PLANNING CONSULTATION RESPONSE

Application No	2026/0232
Proposal	Erection of 119 dwellings, open space and associated infrastructure
Address	Land to the south of Bloomhouse Lane, East of Woolley Colliery Road, Darton, Barnsley
Date of Consultation Reply	21 May 2026
Consultee	Planning Policy

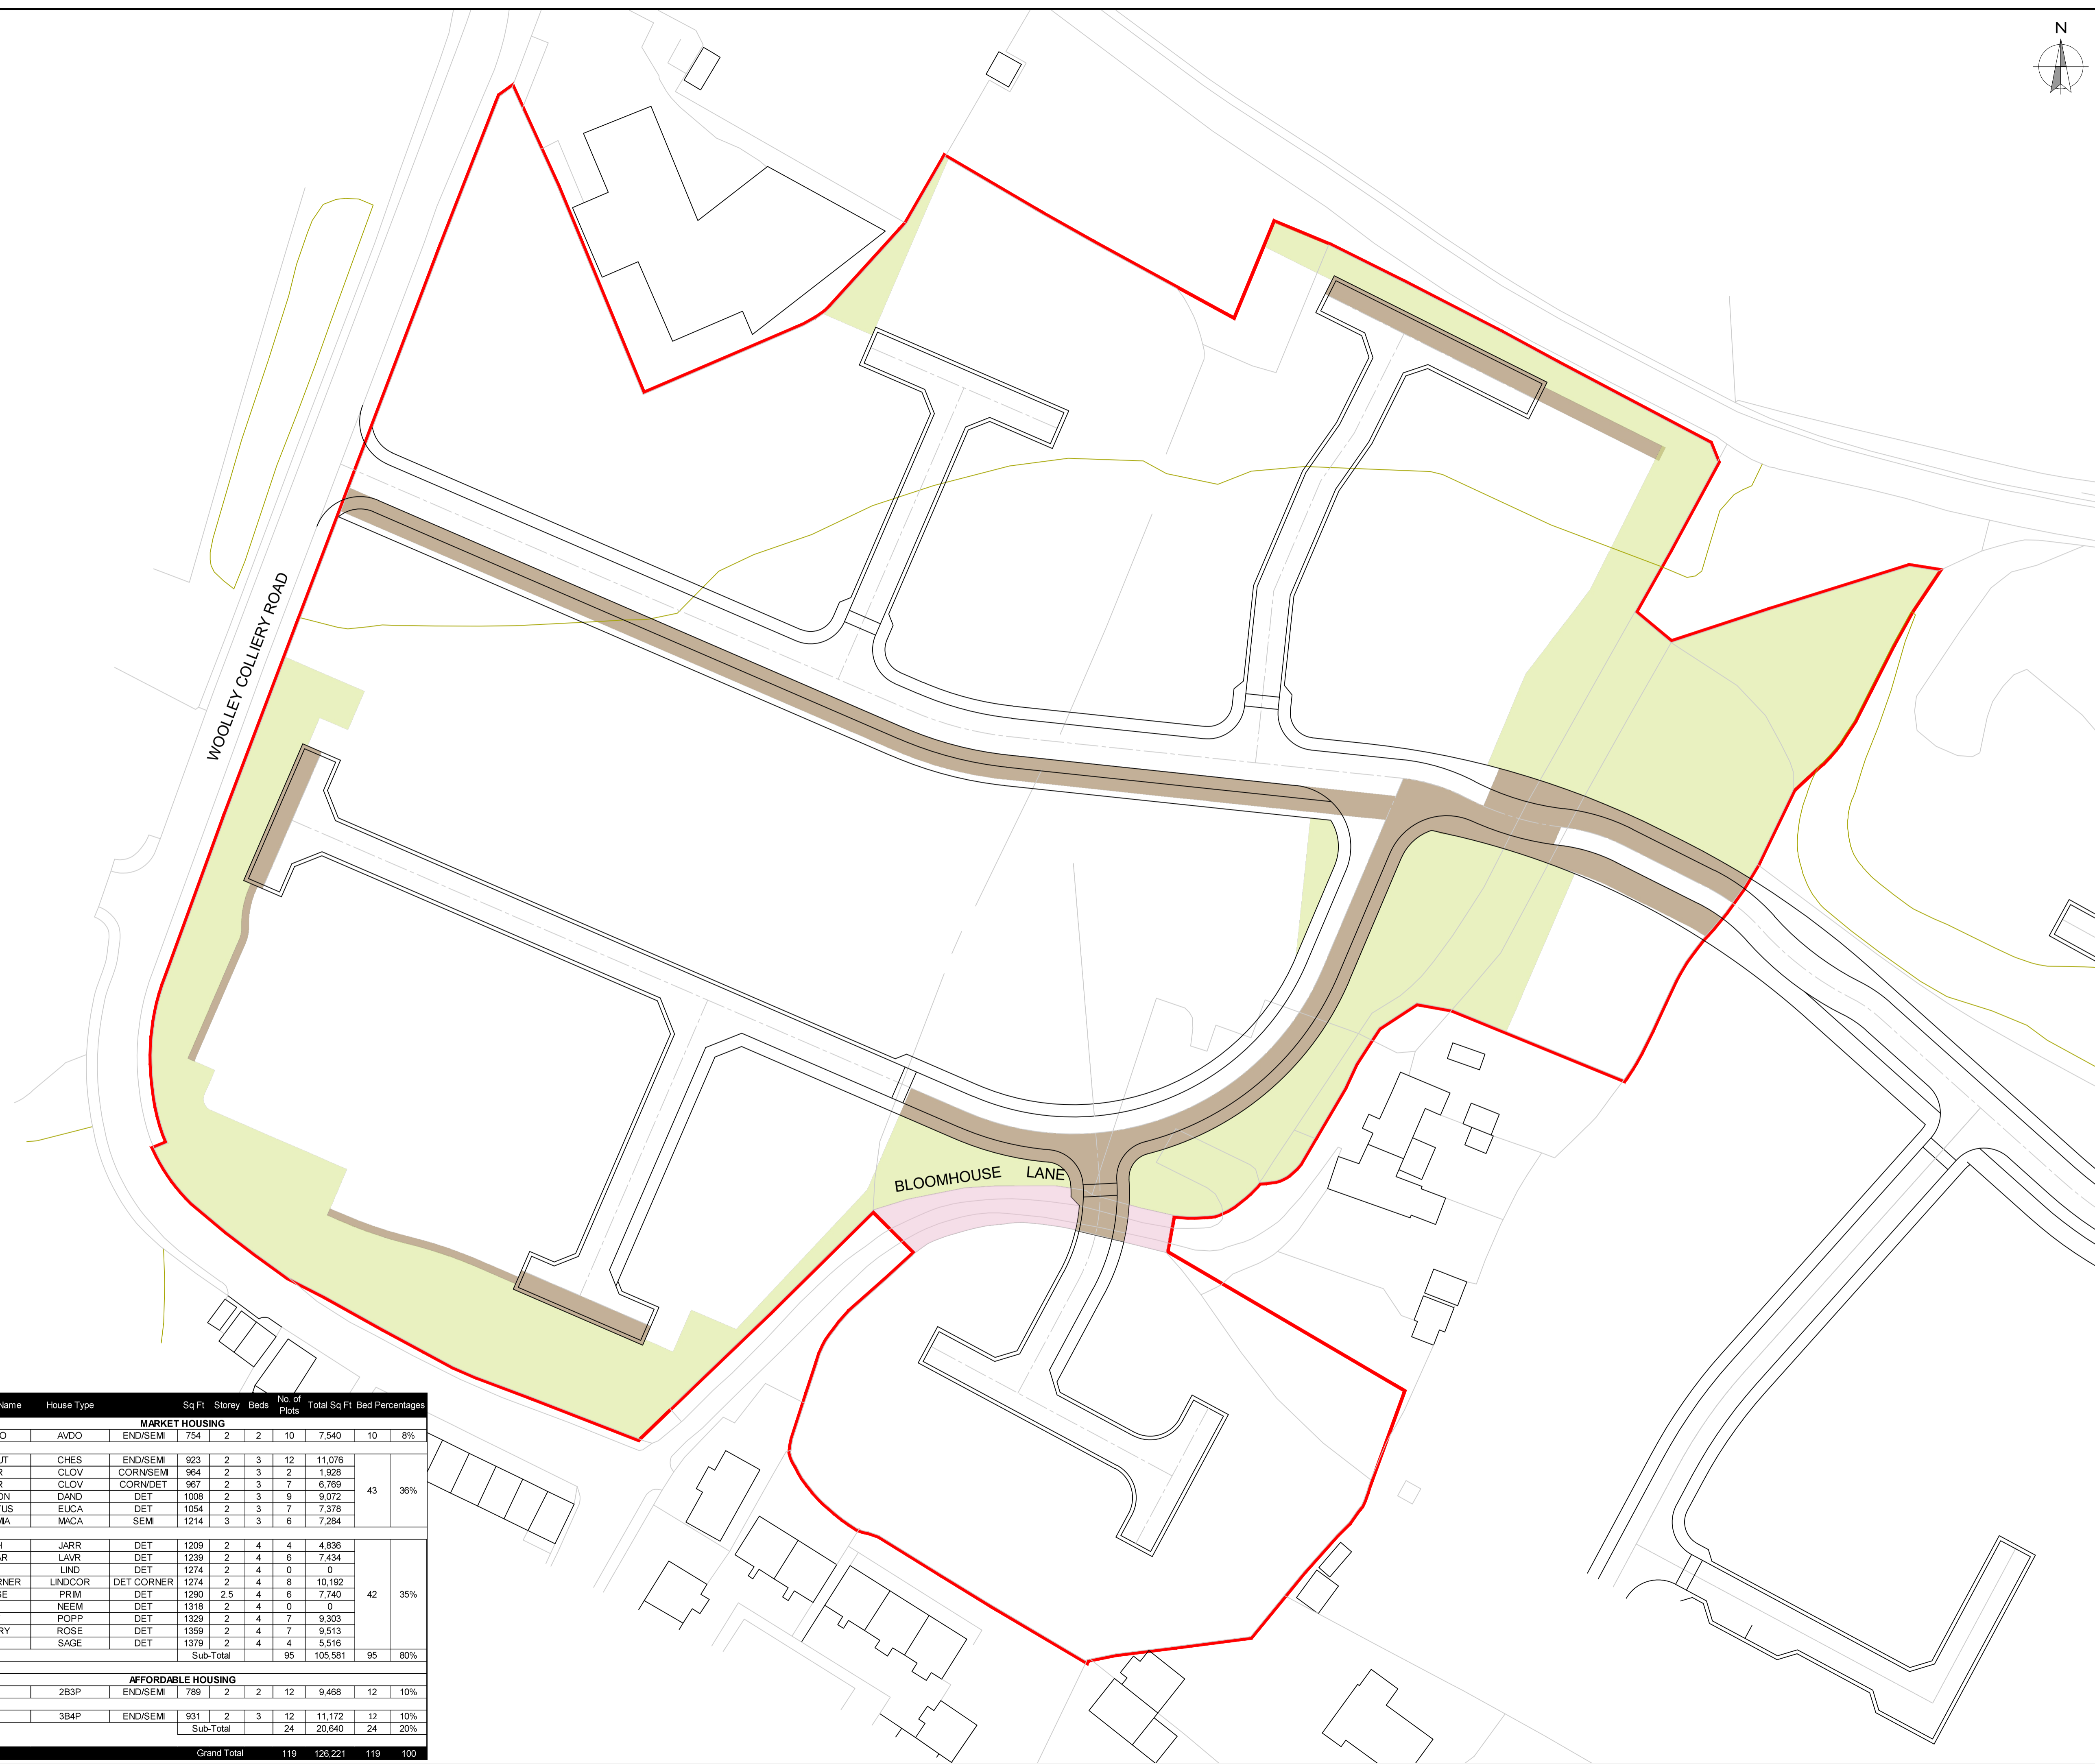
Local Plan policy GS1 Greenspace and the associated SPD Open space provision on new housing developments require an area of open space amounting to 15% of the developable area to be located centrally on the application site and the proposal should be amended to secure this unless the applicant can justify a departure from this approach.

Local Plan policy CC4 Sustainable Drainage Systems requires all major development to use SuDS unless it can be demonstrated that all types of SuDS are inappropriate. The application proposes an attenuation tank under the public open space and should be required to justify a departure from the policy requirement.

Local Plan policy GD1 requires appropriately landscaped boundaries to be provided where sites are adjacent to open countryside. Since the application site bounds Green Belt to the north, the proposal to retain and bolster planting on the north boundary with the Green Belt is supported.
